Planning Application Ref: **AW/279/20/T**

Location: **128 Manor Way, Aldwick, PO21 4HN**

Description of works: **Crown reduction to height 8m and spread 6m 2No. conifer trees**

SITE PLAN (SC. 1:200)

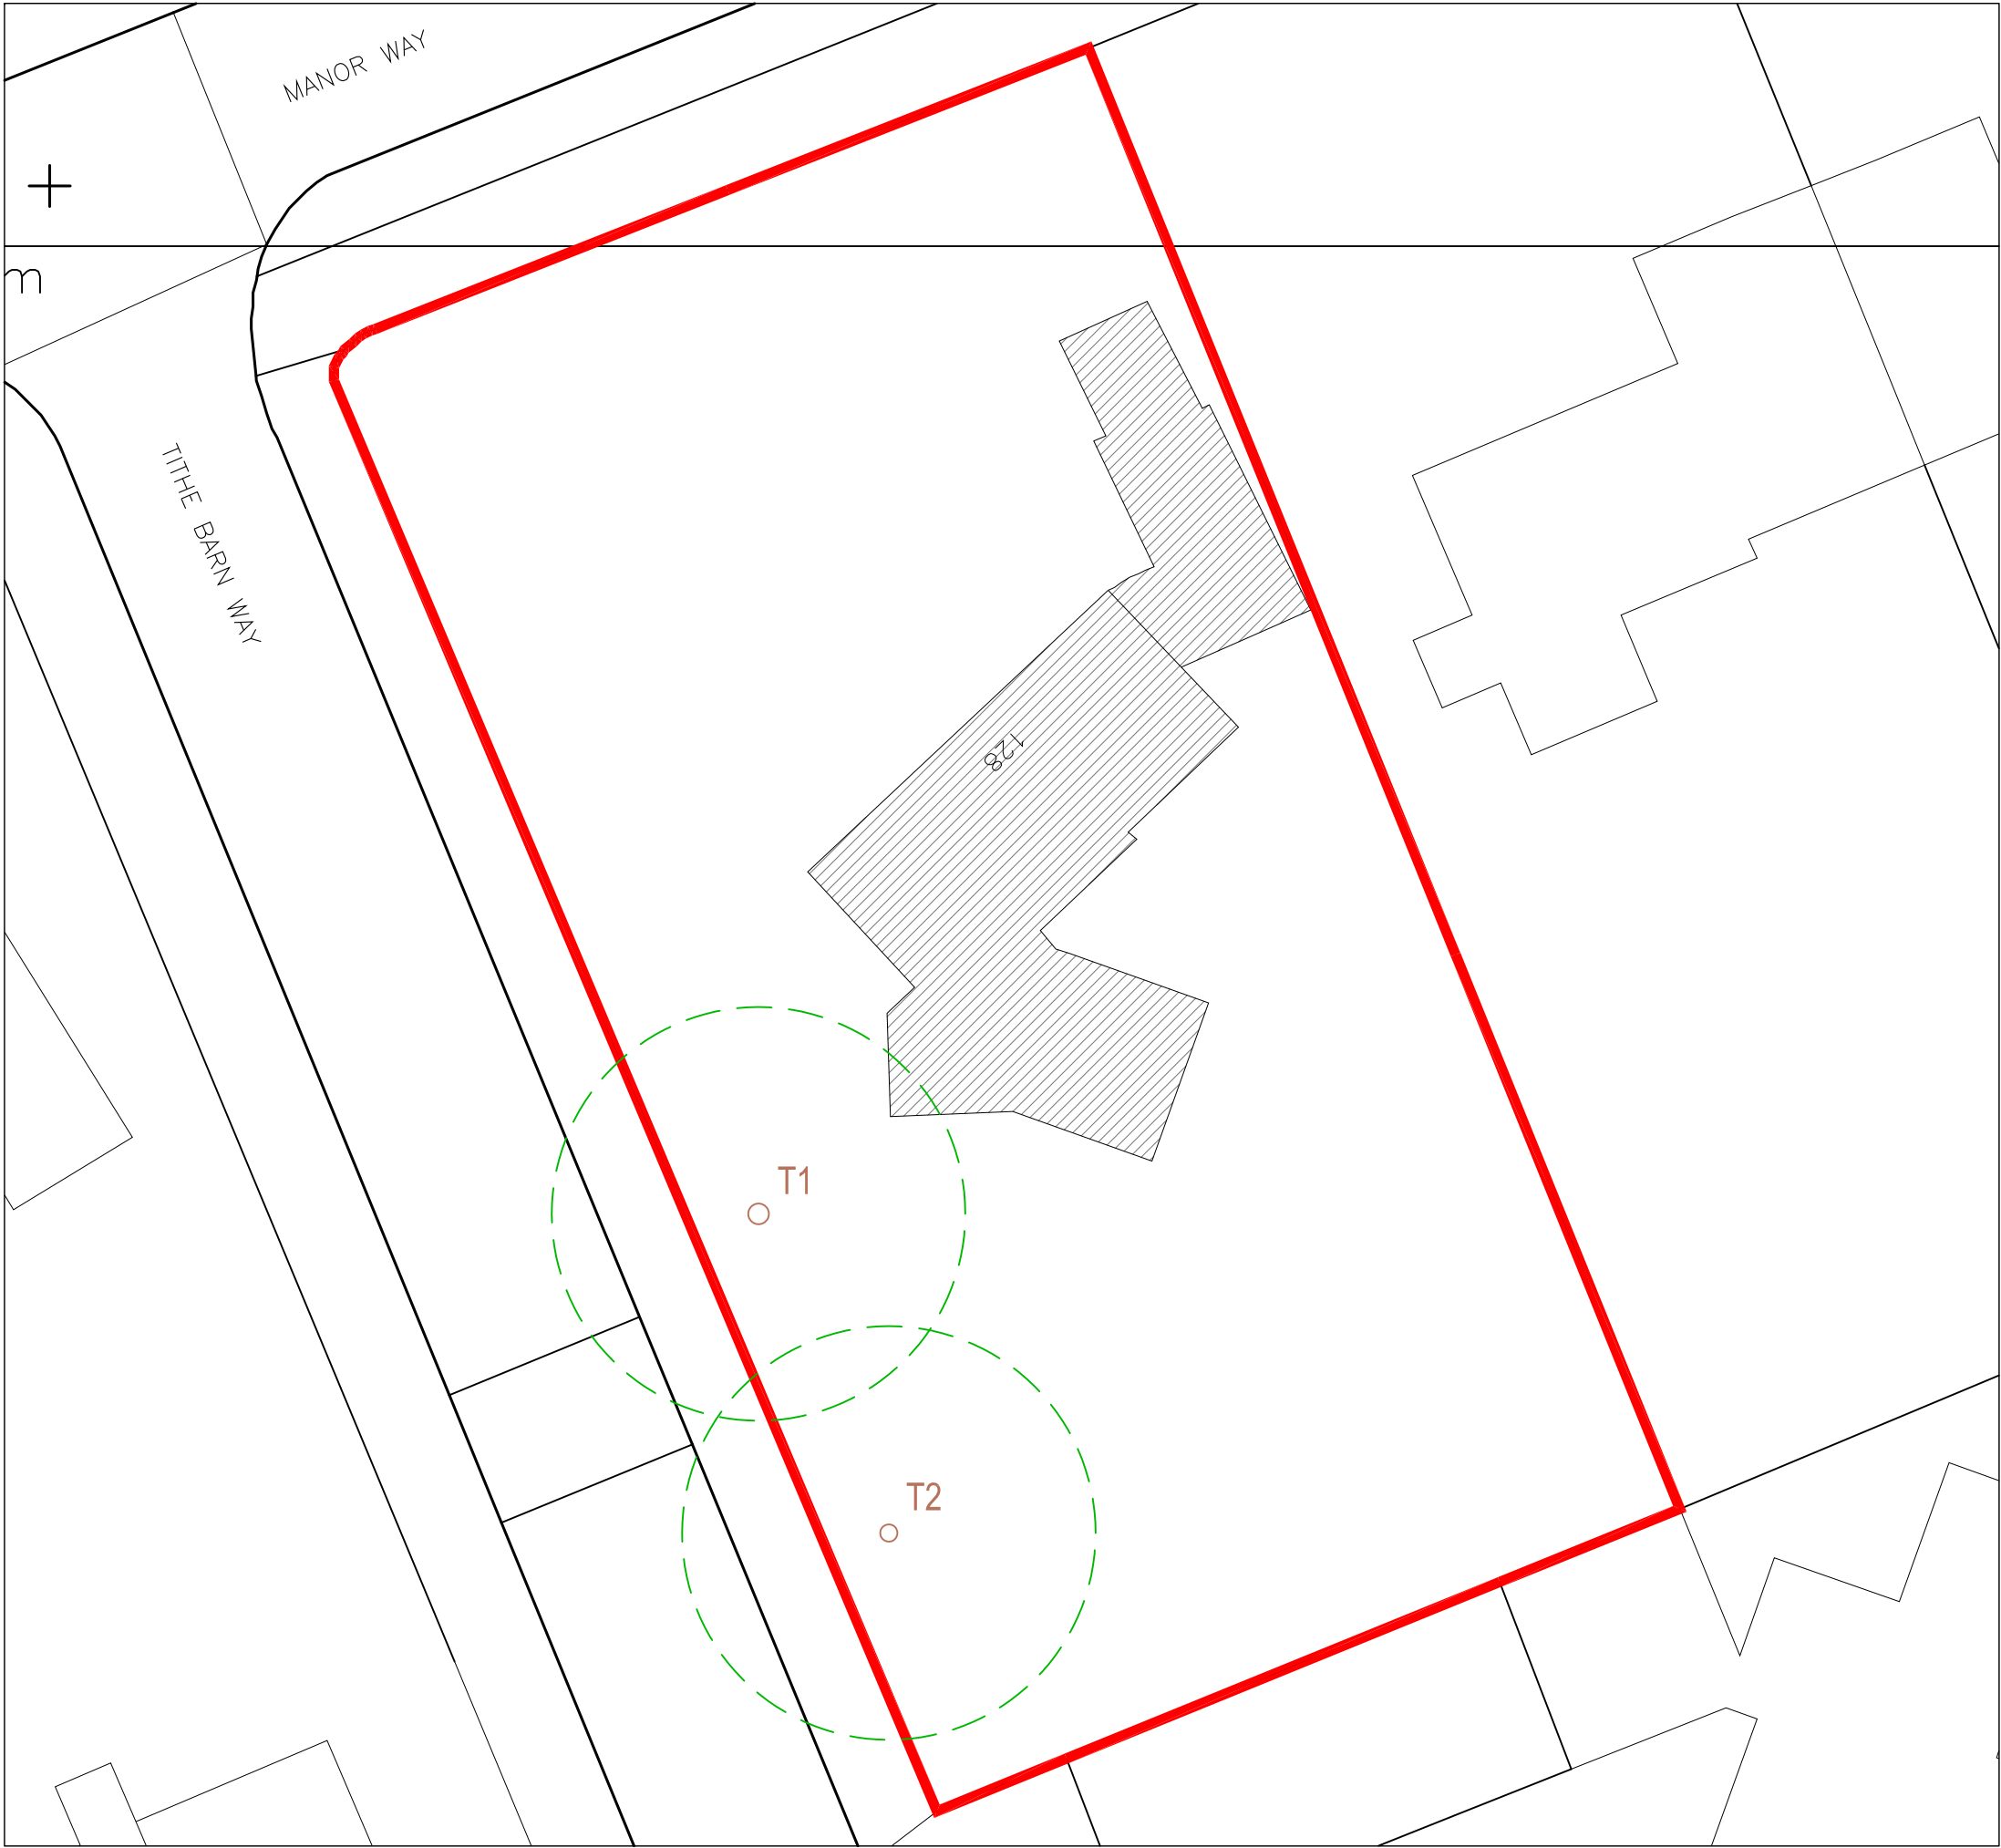
T1 & T2 Monterey cypress / *Cupressus macrocarpa* Approx. height: 12m Average radial spread: 6m Age class: Mature

- Outwardly and from a distance both trees appear to be in a fair physiological state and free from any obvious significant structural defect. They exhibit unmodified and attractive upper crown profiles.

- They grow alongside the dwelling and are most prominent when viewed from Tithe Barn Way, a short section of estate road notable for its conifer tree-lined character – of which these trees are notable constituents. As such, they have public amenity value and contribute to the character of the area.

- These trees require careful management that respects their age and vulnerability to environmental changes and disease progression.
- There is no obvious arboricultural justification for the work proposed. An operation to reduce both the height and lateral spread on all aspects (the correct interpretation of *crown reduction*) by 4m and 3m respectively would not comply with 'British Standard (BS3998:2010) Tree work – Recommendations' and be likely to result in significant harm to the health and vitality of the trees with large pruning wounds being formed as well as undermining their visual amenity value and impact in the landscape. It may ultimately lead to their destruction.

- I register an **Objection** to this proposal and **recommend the making of a Tree Preservation Order** to preserve the trees place in the landscape and better control their future management. I attach a TEMPO form and GIS plan for this purpose.
